RE: 84 Woodhead Road, Holmbridge - 2021/91568 - KC Conservation & Design Comments

I can confirm that these would appear to address my previously stated concerns (see Consultation response dated 18.June 2021) and that I have no further objection to the application.

NOTE: ALL DIMENSIONS SHOWN ARE PROVISIONAL DIMENSIONS ONLY & SHOULD NOT BE READ AS EXACT MEASUREMENTS. THESE MAY NEED TO BE ALTERED DUE TO SITE CONSTRAINTS/ INSPECTION THE DRAWINGS AND DESIGN ARE THE COPYRIGHT OF L'ARCHE DEVELOPMENTS YORKSHIRE LTD & SHOULD NOT BE RE-PRODUCED WITHOUT PRIOR PERMISSION

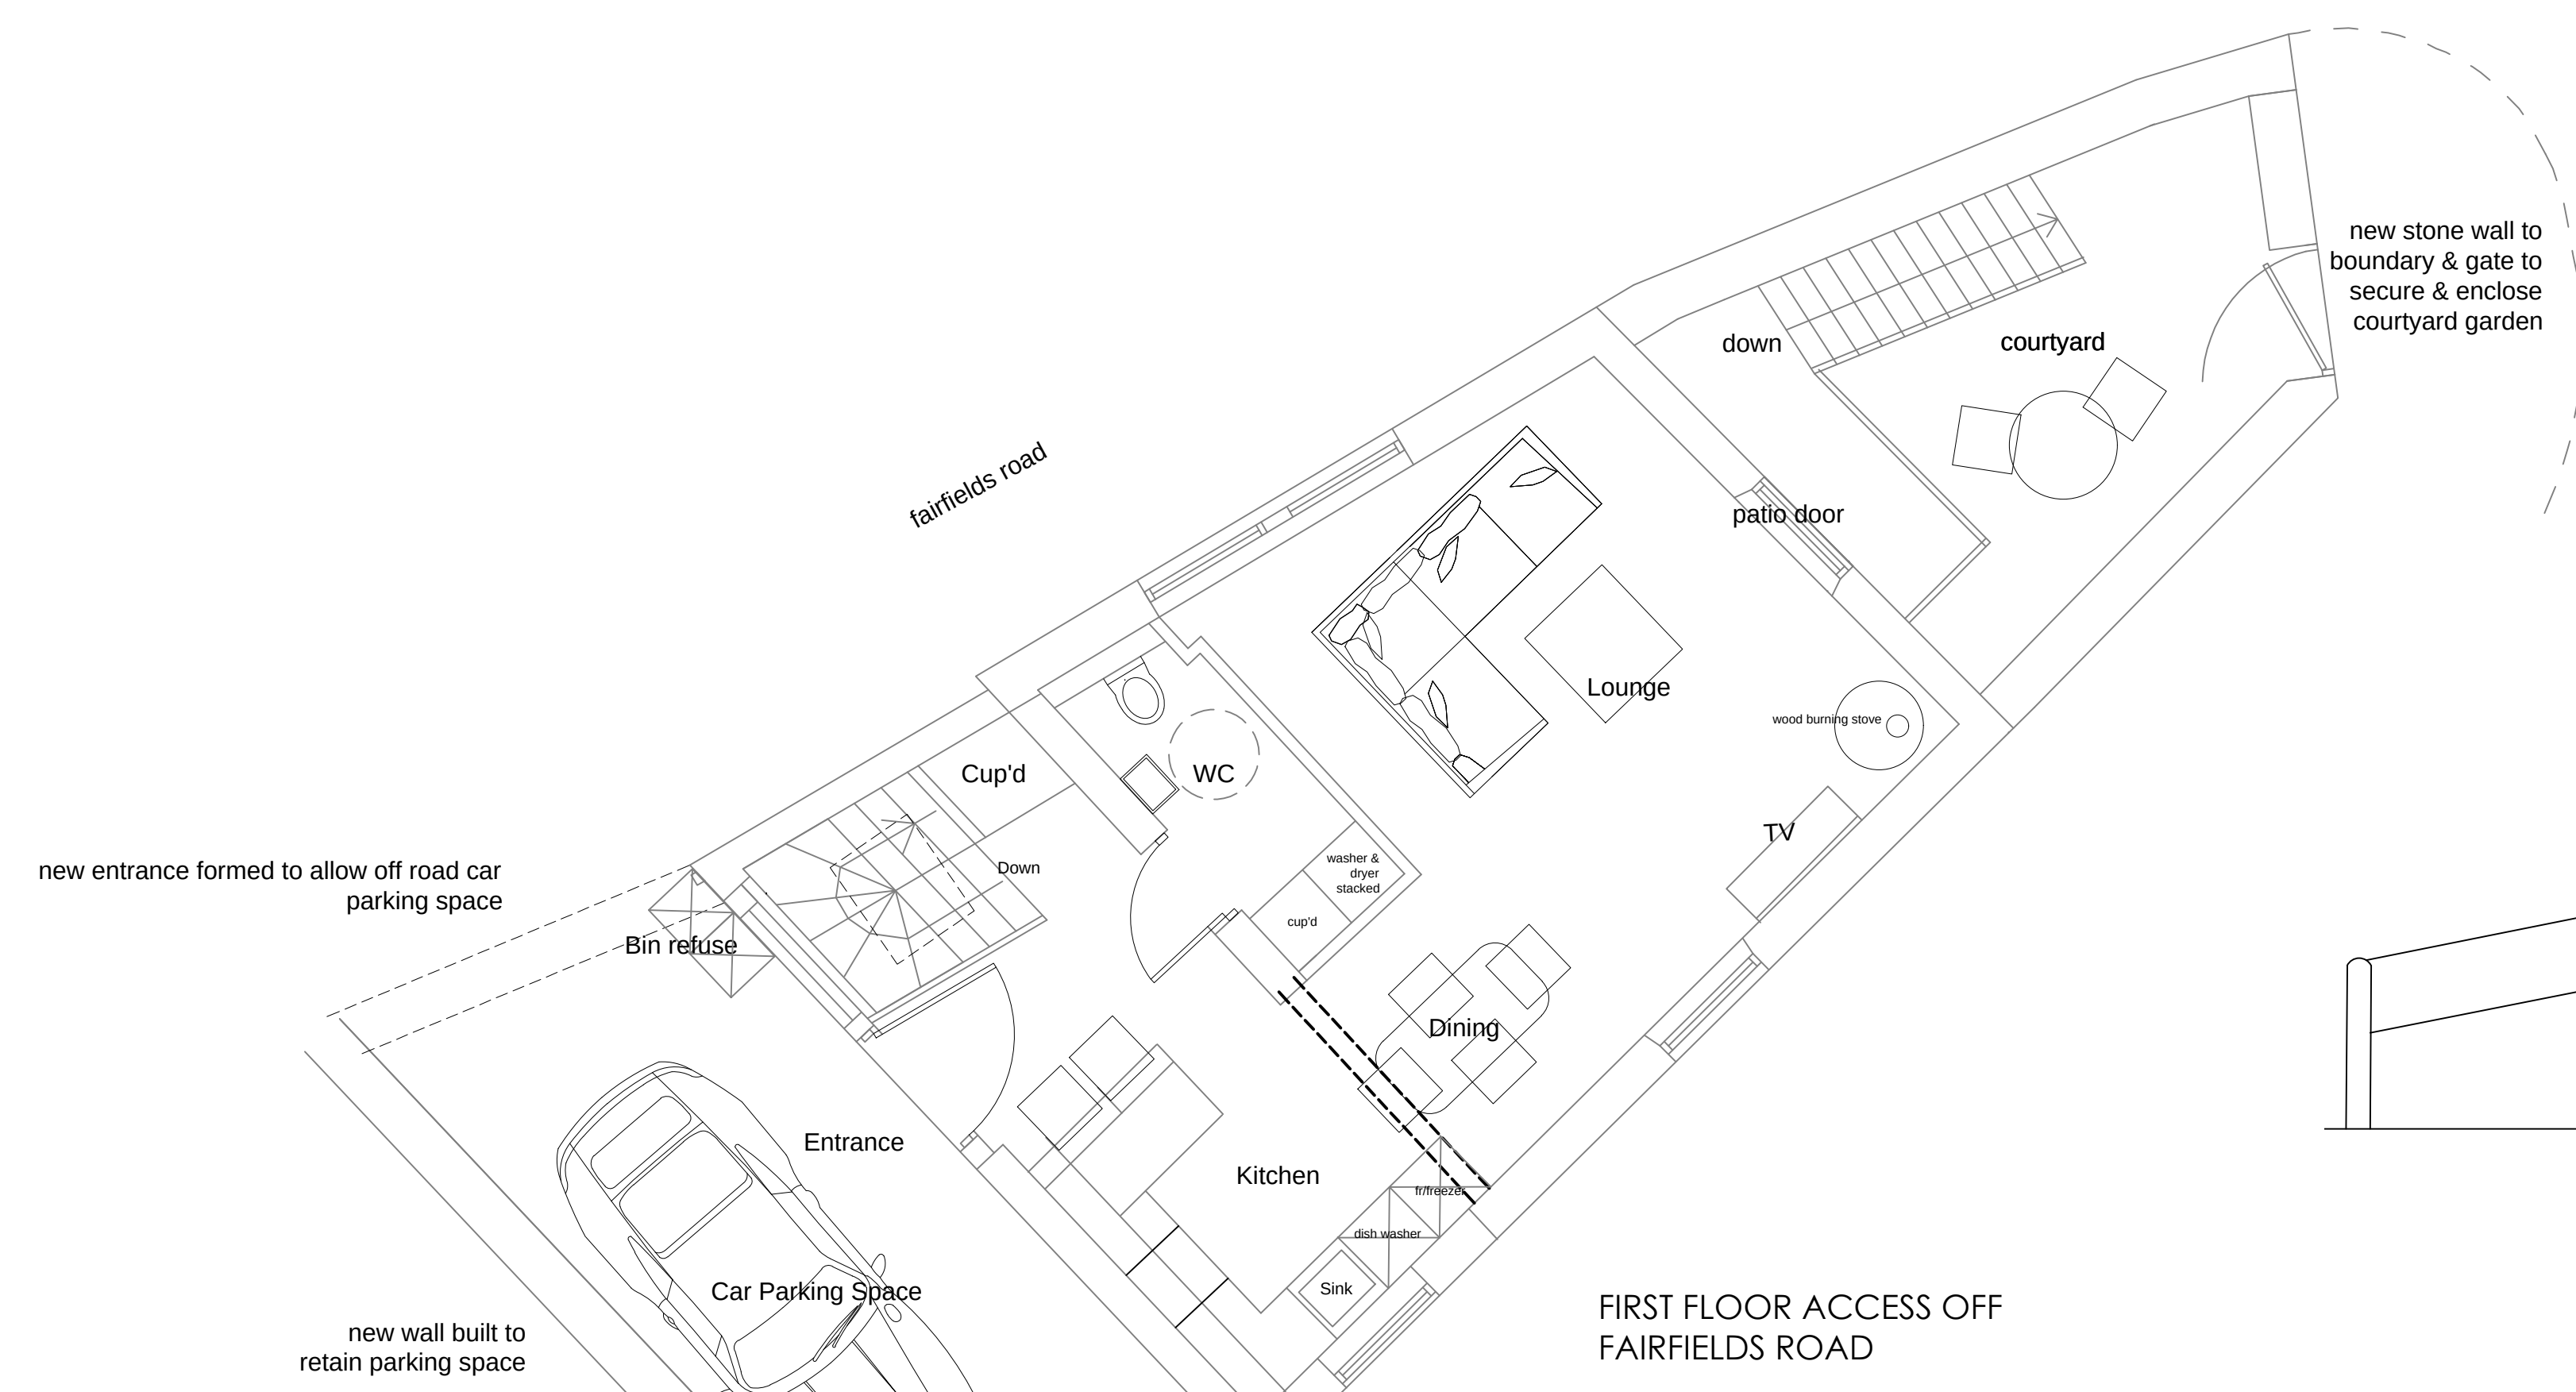
To make it clearer, would you mind adding an annotation to this elevation to say that the boundary wall has been demolished to create a new vehicular access? This would make it clearer to other people viewing the plan.

From your earlier email, I understand that vehicular access and parking are to be off Fairfield Road and that a raised parking platform would be constructed to facilitate this. However, the elevations do not show a new vehicular access on the Fairfield Road elevation, just a small pedestrian access gate. This should be changed so that the proposed new access is clearly shown and annotated on the Fairfield Road elevation.

Please find attached amended prop plans as per your request.

Apologies I missed your call, I was in an appointment, please find attached prop plan, it was showing an older version of the fairfields road elevation, so please find the correct elevation.
